**Re: Tam Le Salon  
130 Coors Blvd NW  
Grading and Drainage  
Engineers Stamp Date 8/10/2015 (K10D047)**

Based upon the information provided in your submittal received 8/11/2015, the above referenced Grading and Drainage Plan cannot be approved for Grading Permit or Building Permit until the following comments are addressed.

## GRADING & DRAINAGE PLAN

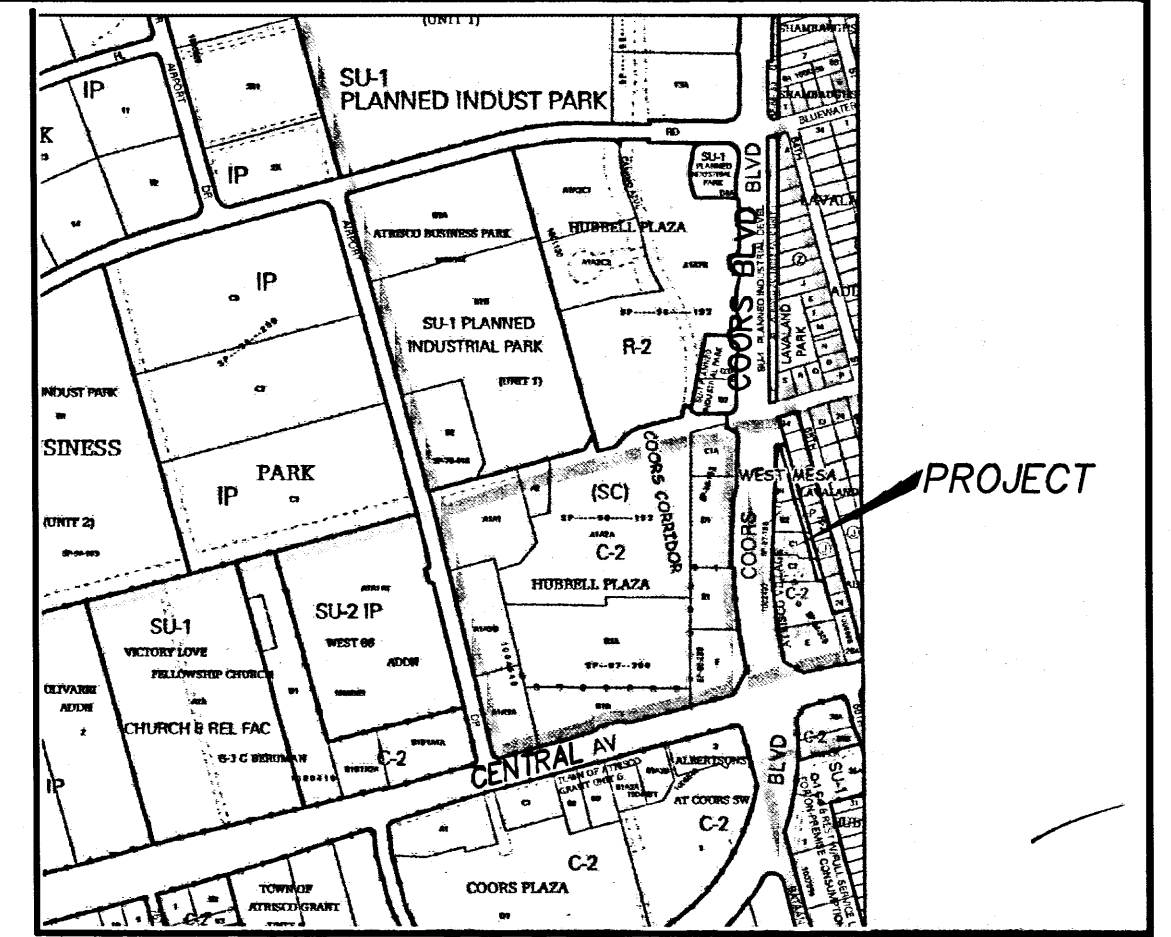
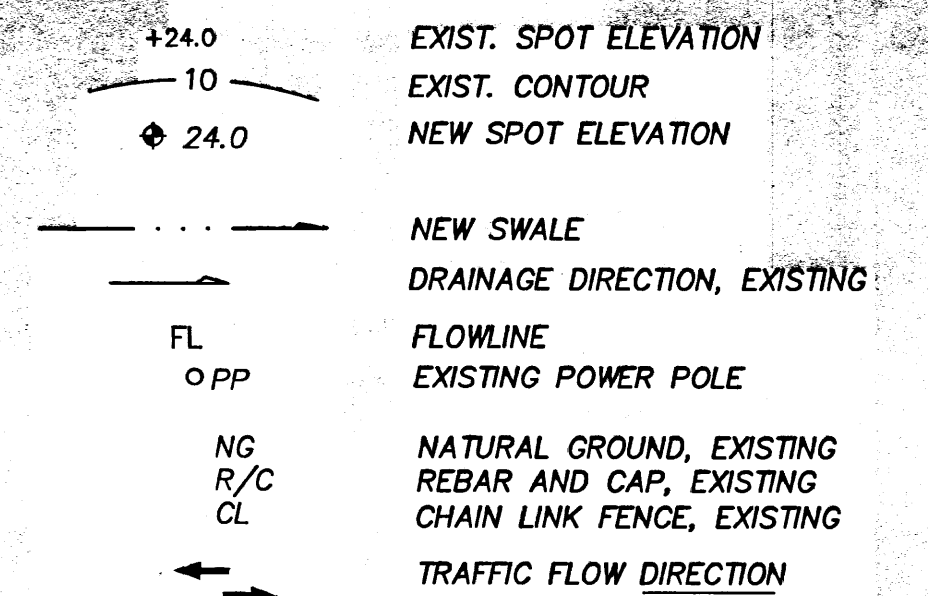
- Provide roof flows.
- Provide flow calculations for the concrete drainage rundown.
- Verify if the system in the sidewalk is a sidewalk culvert or pvc? Provide calculations for either one.
- An access agreement must be provided from the owners to the south.
